Addendum

No. 1

Description: Revise front line beverage casework to accept cart. Separate eyewash from handsink per Code review comments.

Project Title Sheetz C-Store
Sawyer Road
Cameron, NC

5 SELF-SERVE
1/2" = 1'-0"

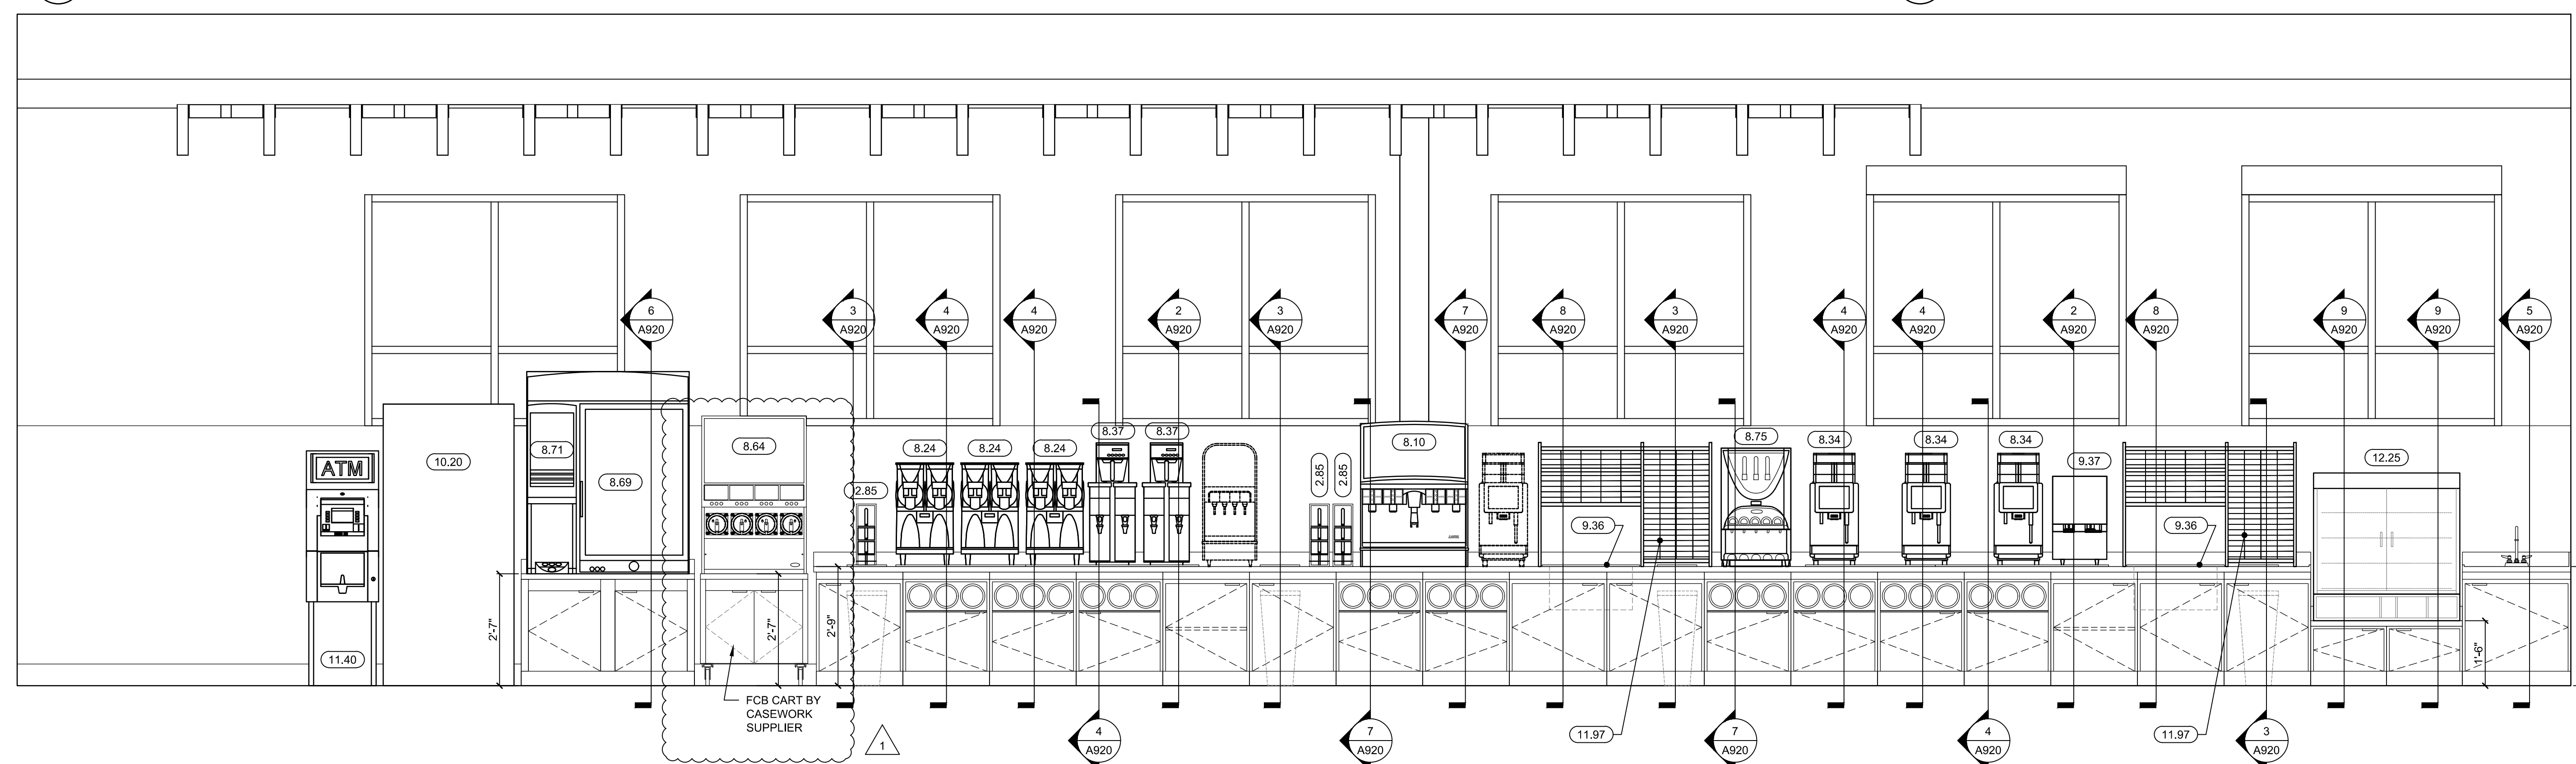
- Item 1: *A800 - EQUIPMENT PLAN- Revised beverage bar countertop. Separated eye wash from sink.*
- Item 2: *A810 - EQUIPMENT ELEVATIONS & DETAILS- Revised beverage bar elevation.*
- Item 3: *A900 - CASEWORK PLANS, ELEVATIONS & DETAILS- Added access panel note to detail 4.*
- Item 4: *A920 - CASEWORK PLANS, ELEVATIONS & DETAILS- Revised beverage bar countertop.*

SHEET TITLE
**IN SLAB
PLUMBING
PLAN**

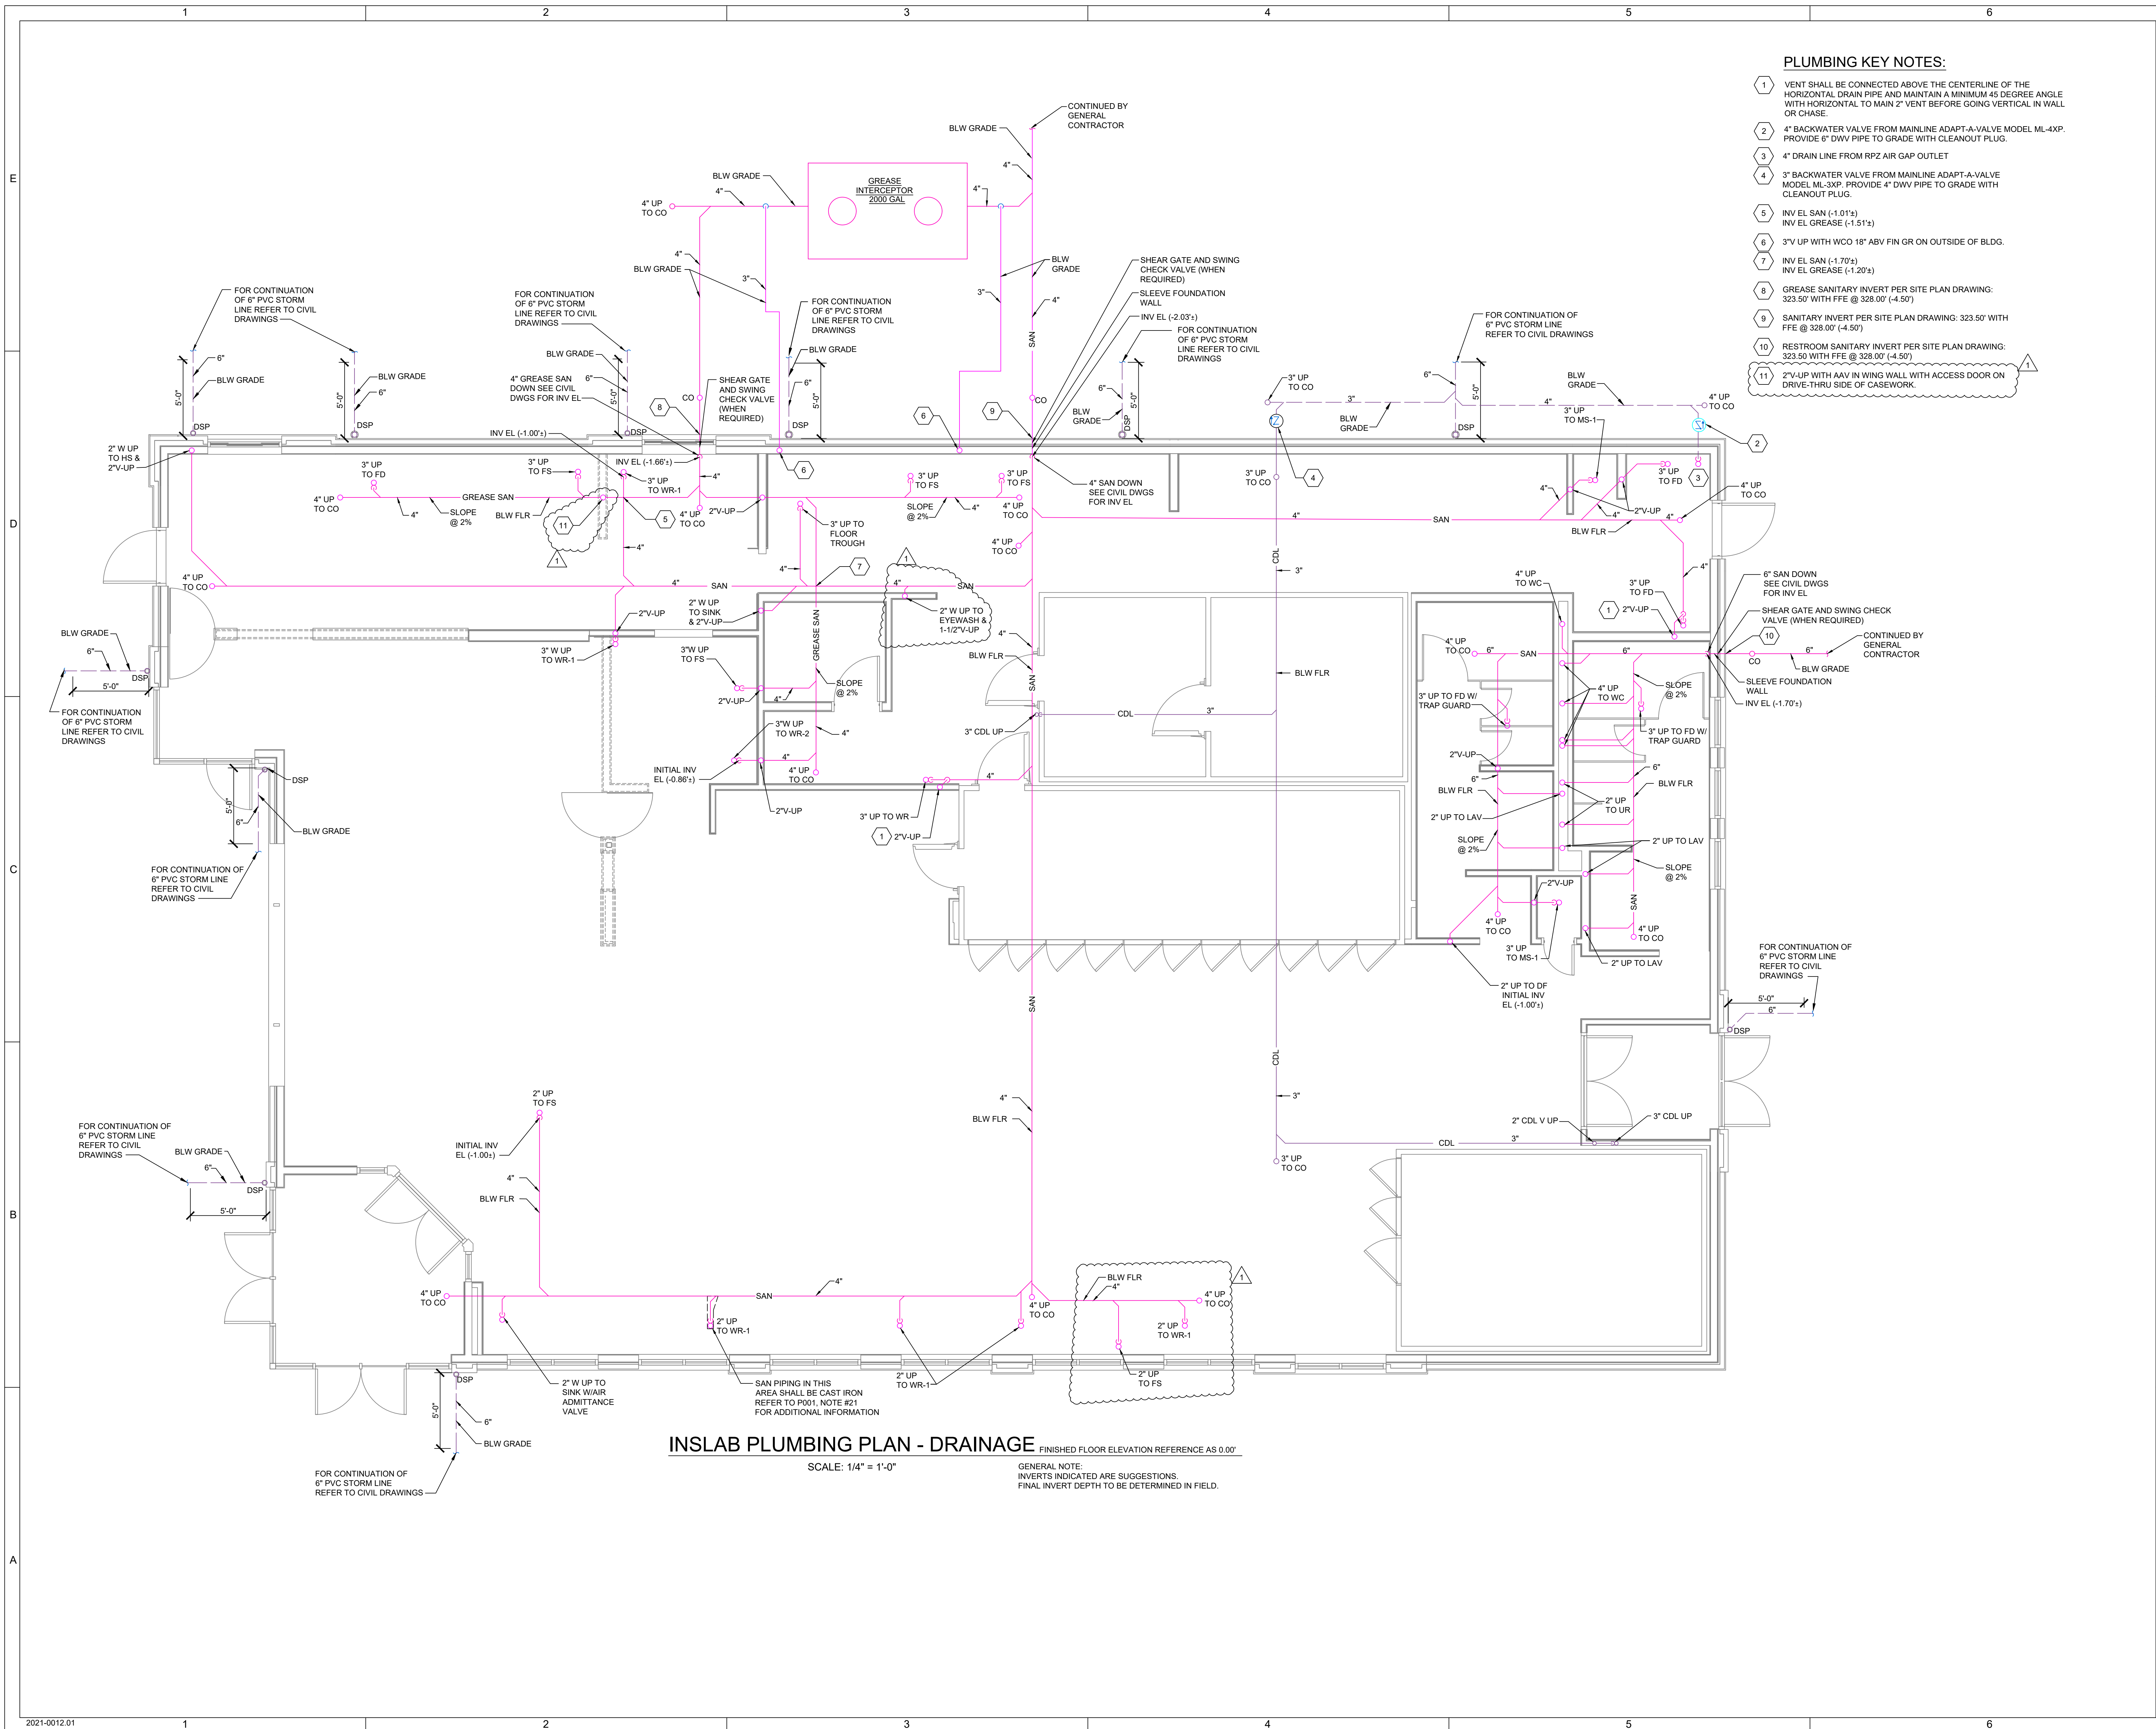
1. RELOCATED location of receptacles and data outlets to accommodate the architectural addition of the FCB Dispenser rolling cart to beverage line area.
2. REMOVED 2"V-up note at drive-thru wing wall and replaced with keynote #11.
3. ADDED keynote #11 - 2"W-up with AAV at wing wall with access door on drive-thru side of casework.
4. ADDED eyewash connection and note.

P102

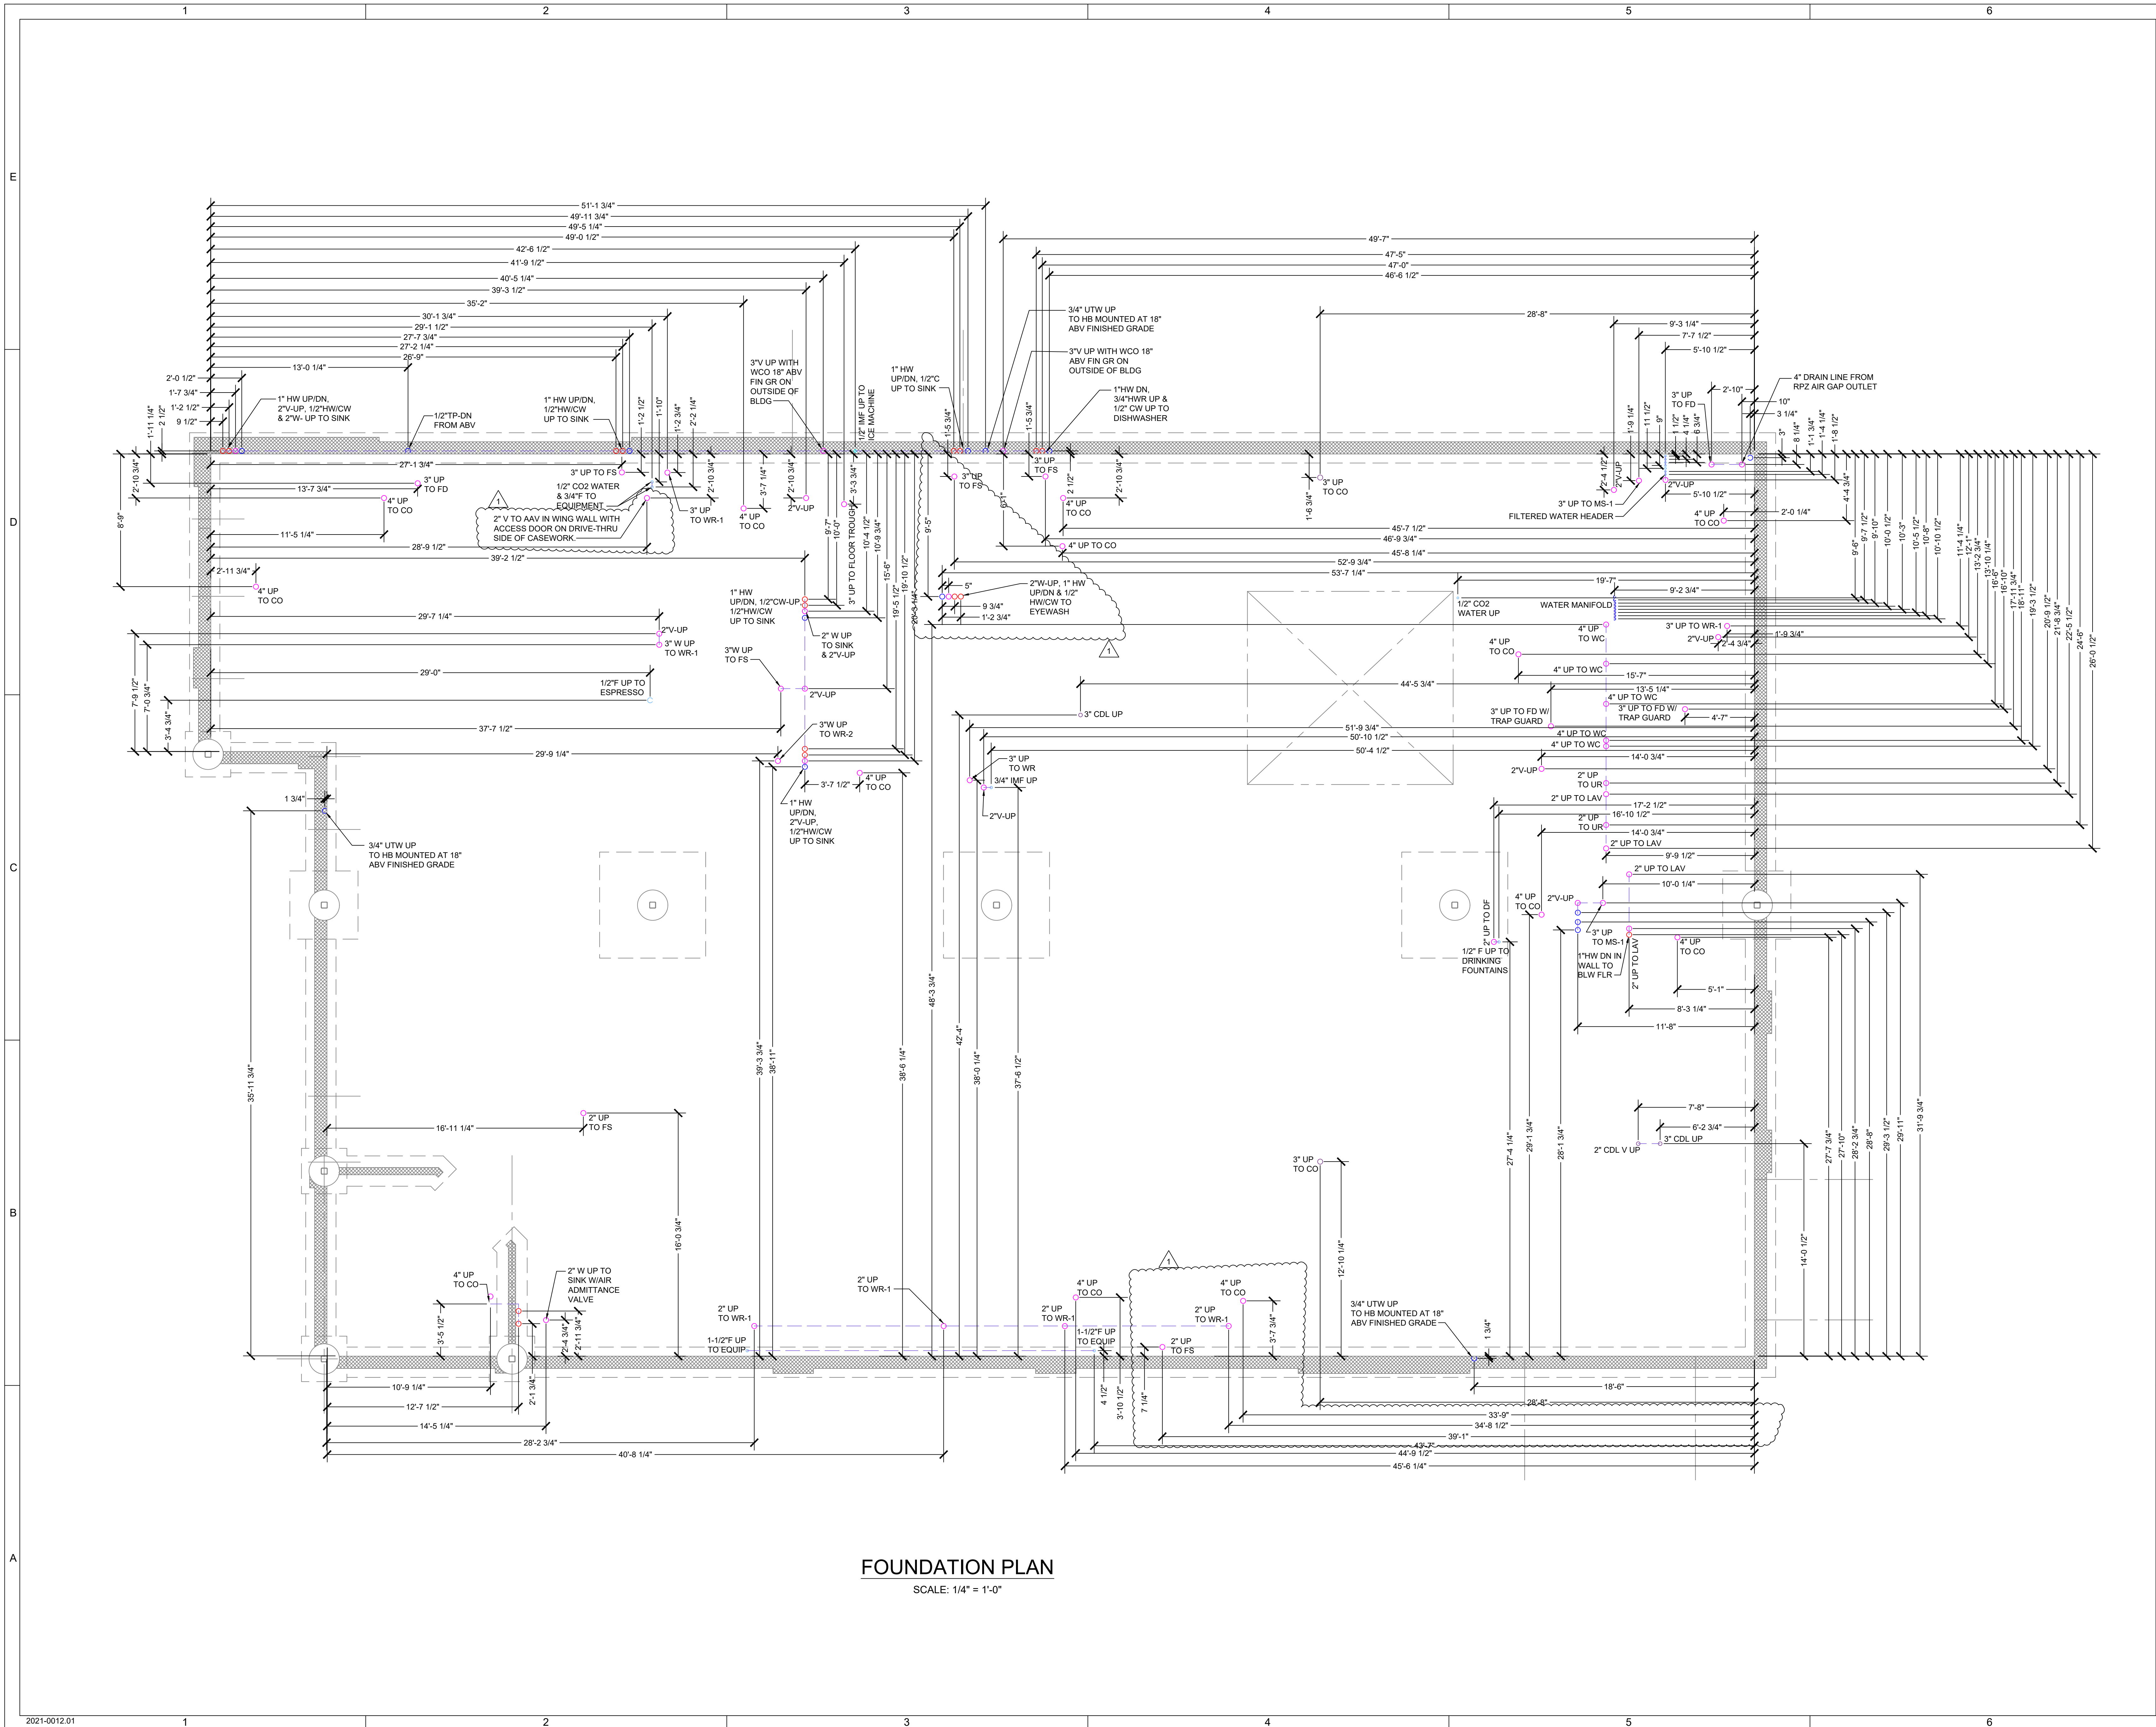
1. REVISED front drain locations and dimensions.
2. REMOVED 2"V-up note at drive-thru wing wall and replaced with 2"W to AAV at wing wall with access door on drive-thru side of casework.
3. ADDED eyewash connections and associated dimensions.
